Our ref: NI12160

Appeal by DUSEK DESIGN ASSOCIATES LTD

Site Address: 18 Linksway, Northwood, HA6 2XB

Further to your letter dated 23 November I comment as follows on the Council's written statement in relation to the above appeal.

rev.	date	description
scale:	1: 100	A0 date: 12 / 01 / 2021
drawing no:	1366 / P / 10	drawn: FJ
drawing:	PLANNING PROPOSALS COMPARISON PLANS	
project:	LAND AT 18 LINKSWAY, NORTHWOOD, MIDDLESEX, HA6 2XB	
client:	DDA

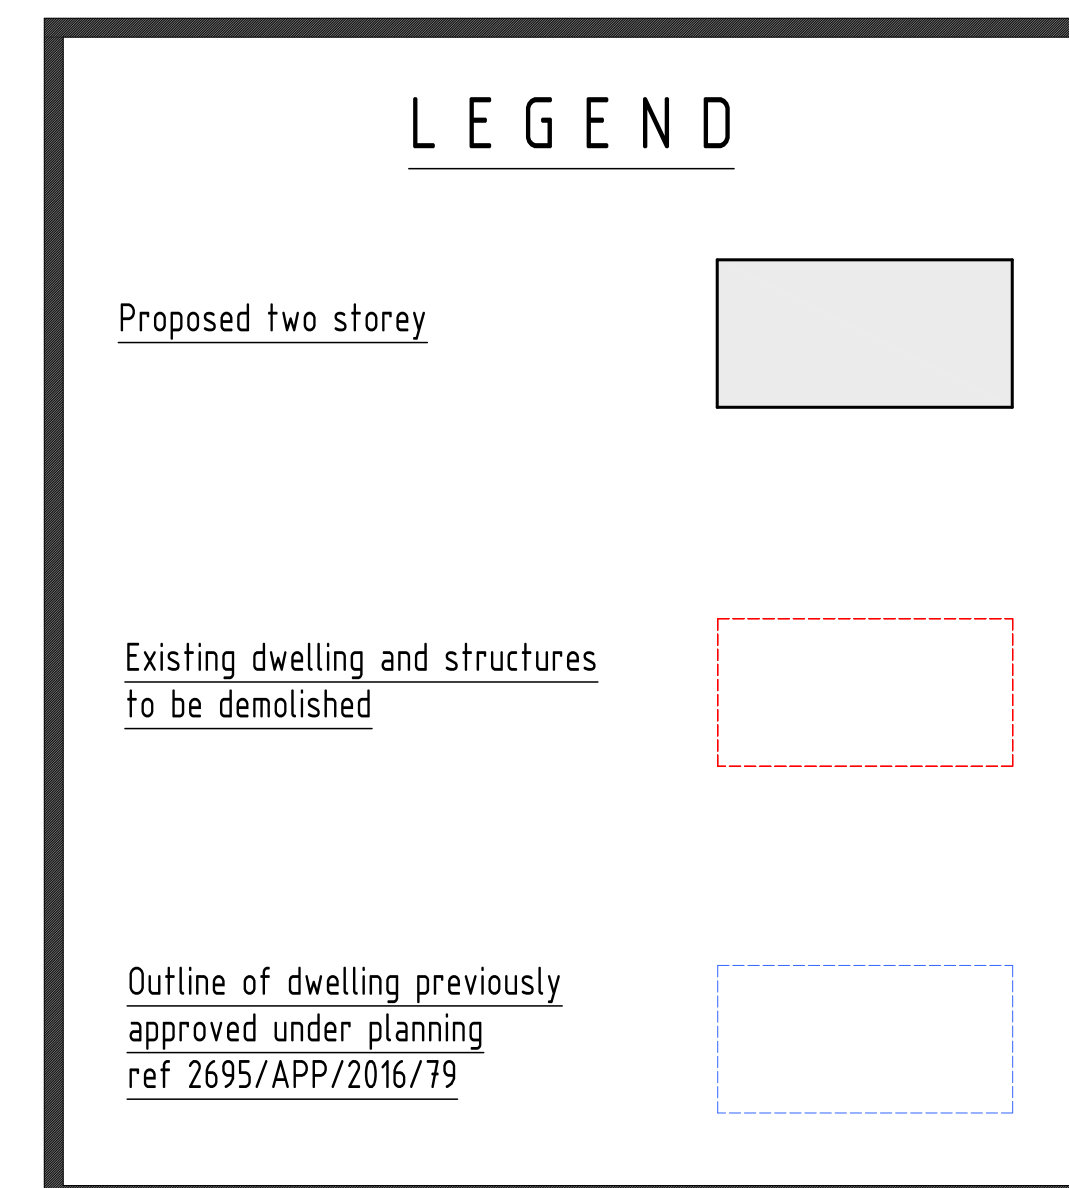
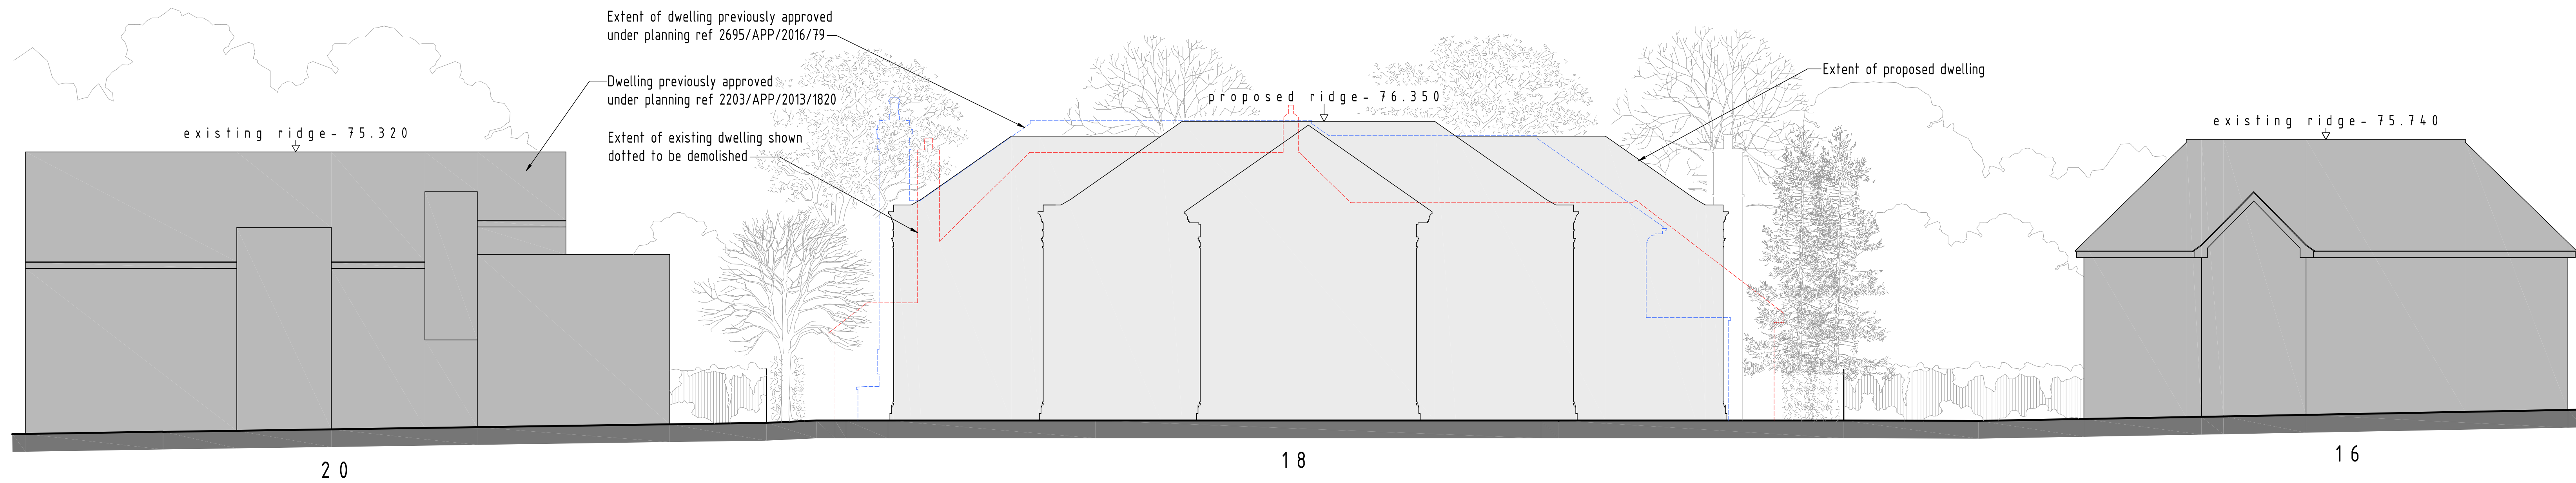
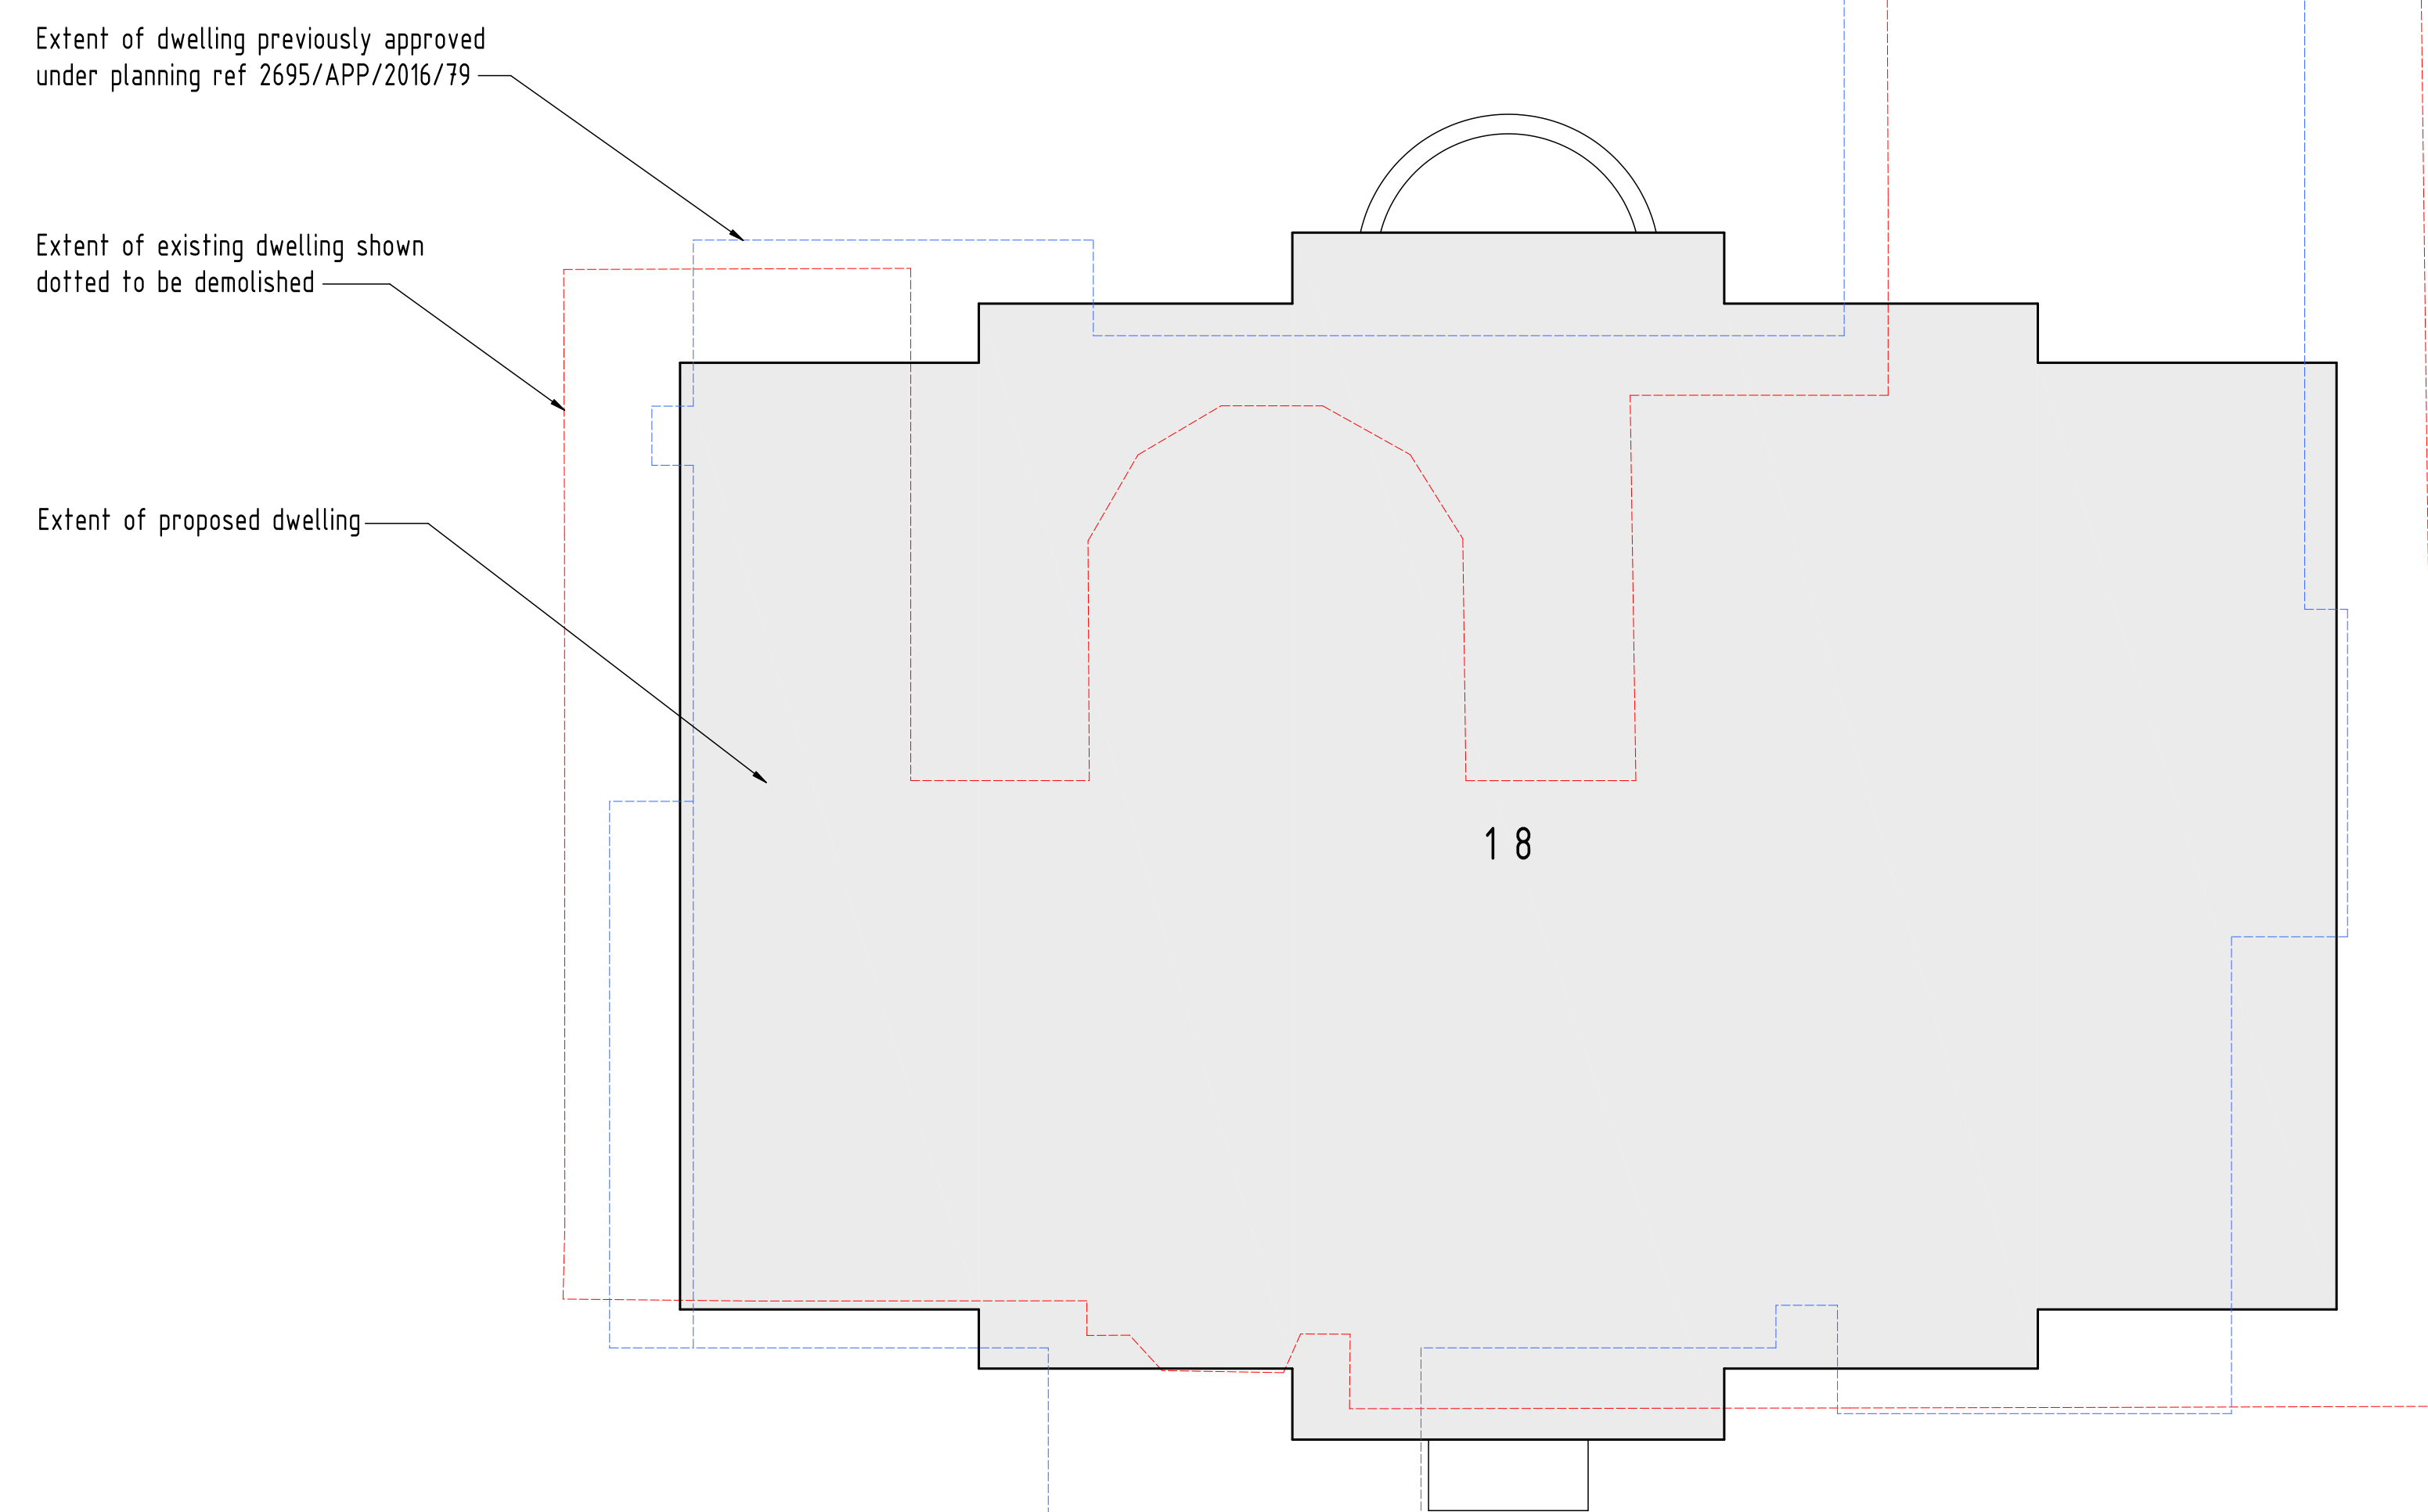
In relation to paragraph 2.1, the Comparison Plan submitted with the original application (drawing no. 1366/P/10 – Appendix 2 of the Appellant's Statement) shows that that our proposal dwelling is comparable with the existing dwelling and approved scheme, and with regard to the latter is smaller in most areas.
